**From:** [Mau, Russell E \(DOH\)](#)  
**To:** [Chace Pedersen](#)  
**Cc:** [Holly Erdman](#); [Smits, Brenda M \(DOH\)](#)  
**Subject:** RE: SP-23-00001 Egan - Notice of Application  
**Date:** Friday, March 17, 2023 6:56:33 AM

RE: SP-23-00001 Egan Short Plat

**TO:** All Staff  
**FROM:** Public Works Plan Review Team  
**DATE:** March 30<sup>th</sup>, 2023  
**SUBJECT:** SP-23-00001 Egan

EGAN SHORT PLAT

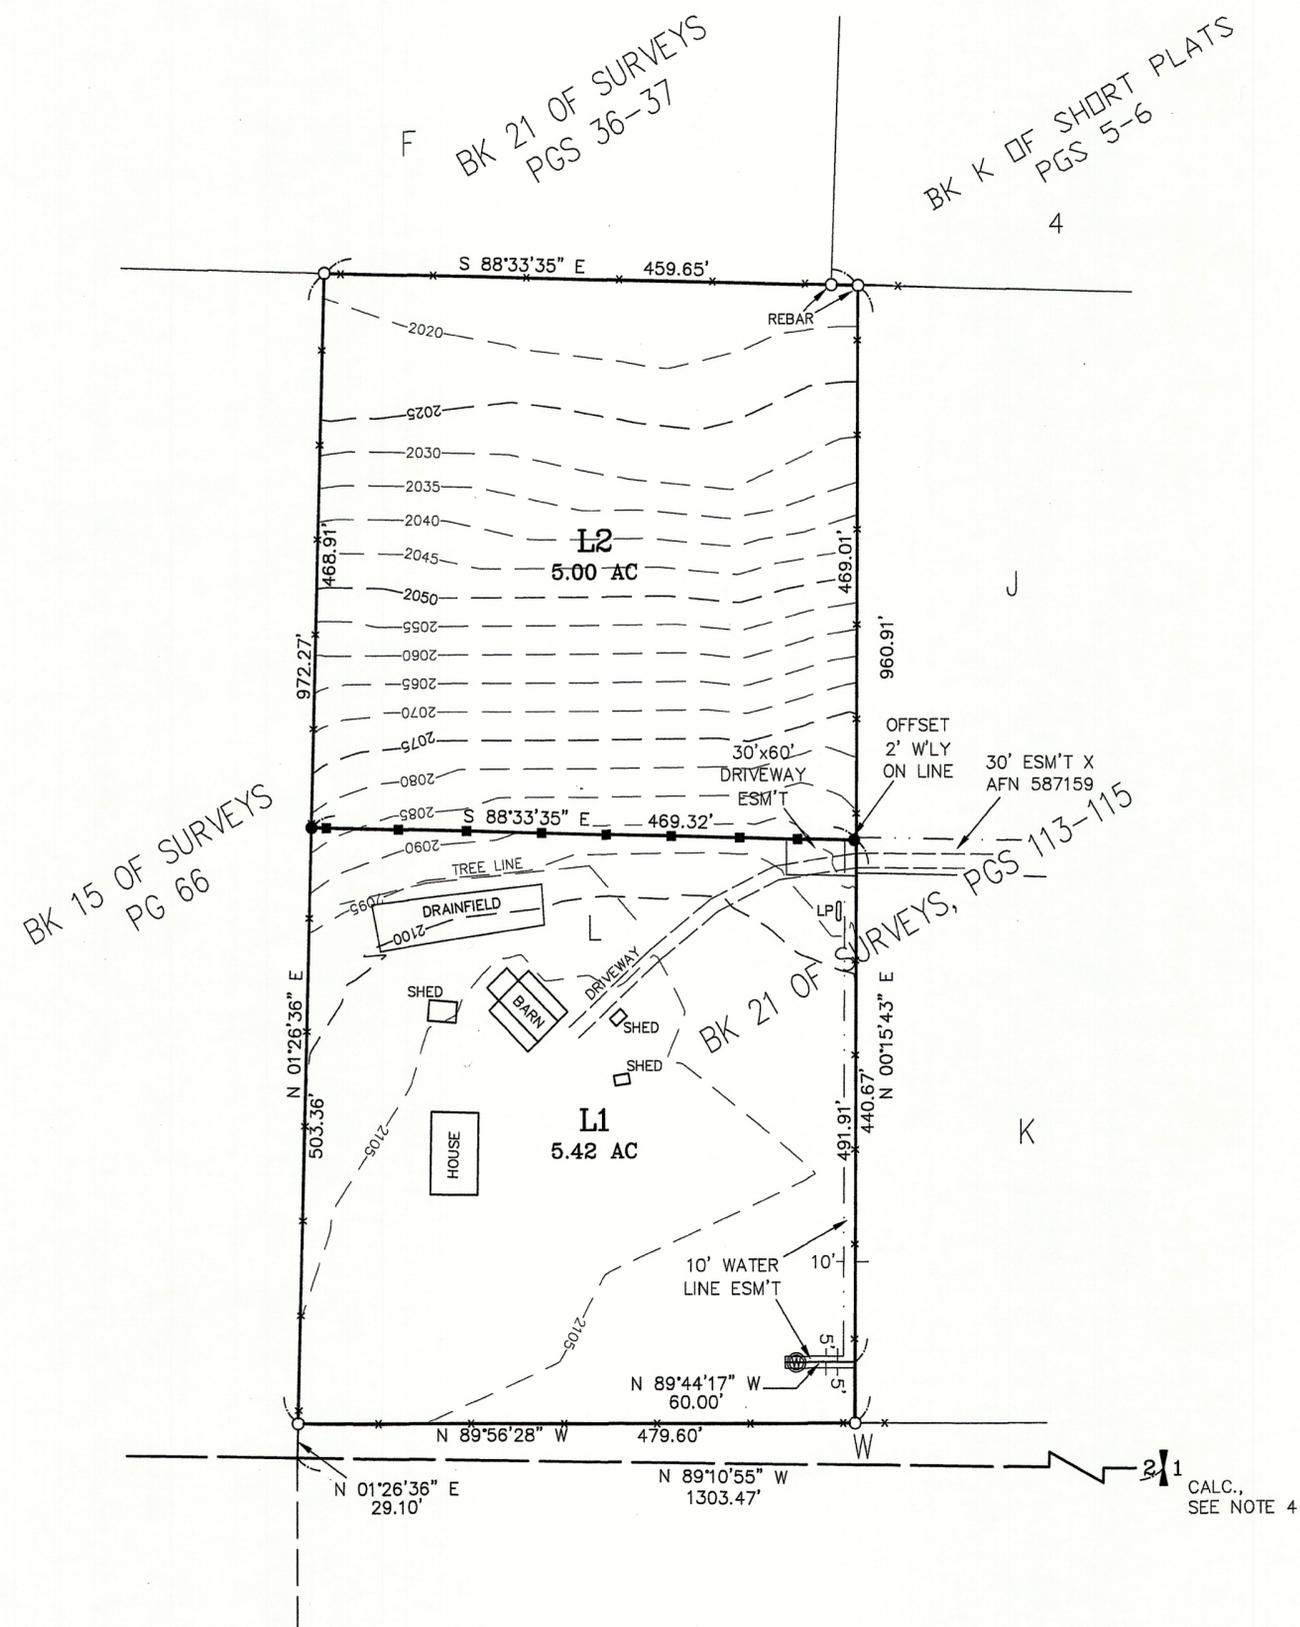
Proposed short plat indicates shared wells will be used. If the intention is to utilize a shared well, a signed, notarized, and filed shared well users agreement will also need to be provided before the short plat is finalized. If shared wells are to be utilized, the wells must be drilled a minimum of 50 feet from any proposed property line and a signed, notarized and recorded shared waters users' agreement for each shared well must be submitted to our office prior to final plat approval. The applicant must prove physical availability of water for all new uses of water proposed lots of this project, which can be provided by (See Condition A-1) a well log or 4 hour draw down test as proof of water availability for each new well proposed. All persons who

I own parcel 655534, neighboring directly east of the proposed short plat (parcel 452836). Those parcels, along with neighboring parcel 442836, are served by an ingress/egress easement on which is a single-lane gravel road. This road is in a nearly constant state of disrepair due to its current traffic load, is not wide enough to accommodate opposing traffic, and includes a dangerous sharp blind corner that affects traffic to/from all involved parcels. Given that the state of this road is insufficient even for its current usage, increasing its traffic load with an additional parcel is very unwise from a safety standpoint, especially considering hazardous winter conditions and potentially restricted emergency vehicle access.

Easement X road surface has only ever been 14 feet wide at most over its entire length since it was excavated in 1995. This is due to steep embankments on either side of the lower half, and a runoff ditch along one side and embankment of the opposite side along the upper half. This makes it impossible for vehicles to pass in opposing directions. Especially at the steep, sharp, blind corner (see accompanying photos). Increased traffic will also increase the likelihood of more frequent head-on encounters making travel for all parties affected awkward and difficult. In addition, winter conditions compound these difficulties, including access by emergency vehicles.

<b>SURVEY</b>	<ol style="list-style-type: none"> <li>1. Preliminary plat does not meet the requirements of WAC:332-130-145 in regard to contour line sources, vertical datum, and contour accuracy.</li> <li>2. The 30x60 driveway easement should be labeled as existing, herein created, or created via separate document. (JT).</li> </ol>
<b>FLOOD</b>	Parcel #452836 is not located in the FEMA mapped special flood hazard area (100-year floodplain).
<b>WATER MITIGATION/ METERING</b>	<p>The following comments outline the requirements for legal availability of water and metering for the proposed short plat:</p> <p>The applicant must provide legal water availability for all new uses on the proposed lots of this project, which can be provided through a mitigation certificate.</p> <p>In accordance with KCC Chapter 13.35.027, the applicant shall provide one of the following documents before final plat approval:</p> <ol style="list-style-type: none"> <li>1. A letter from a water purveyor stating that the purveyor has adequate water rights and will provide the necessary water for the new use;</li> <li>2. An adequate water right for the proposed new use; or</li> <li>3. A certificate of water budget neutrality from the Department of Ecology or other adequate interest in water rights from a water bank.</li> </ol> <p>All applicants for land divisions shall also submit information on "proximate parcels" held in "common ownership" as those terms are defined in WAC 173-539A-030 and otherwise demonstrate how the proposed new use will not violate RCW 90.44.050 as currently existing or hereafter amended.</p> <p>Failure to obtain mitigation before commencement of an activity requiring mitigation shall be a code violation subject to enforcement under Title 18 KCC.</p> <p><b>Final Plat Notes</b></p> <p>The following notes shall be placed on the face of the plat:</p> <p>C-1 "Metering is required for all new uses of domestic water for residential well connections and usage must be recorded in a manner consistent with Kittitas County Code Chapter 13.35.027 and Ecology regulations."</p> <p>C-2 "The approval of this division of land provides no guarantee that use of water under the ground water exemption (RCW 90.44.050) for this plat or any portion thereof will not be subject to curtailment by the Department of Ecology or a court of law."</p>
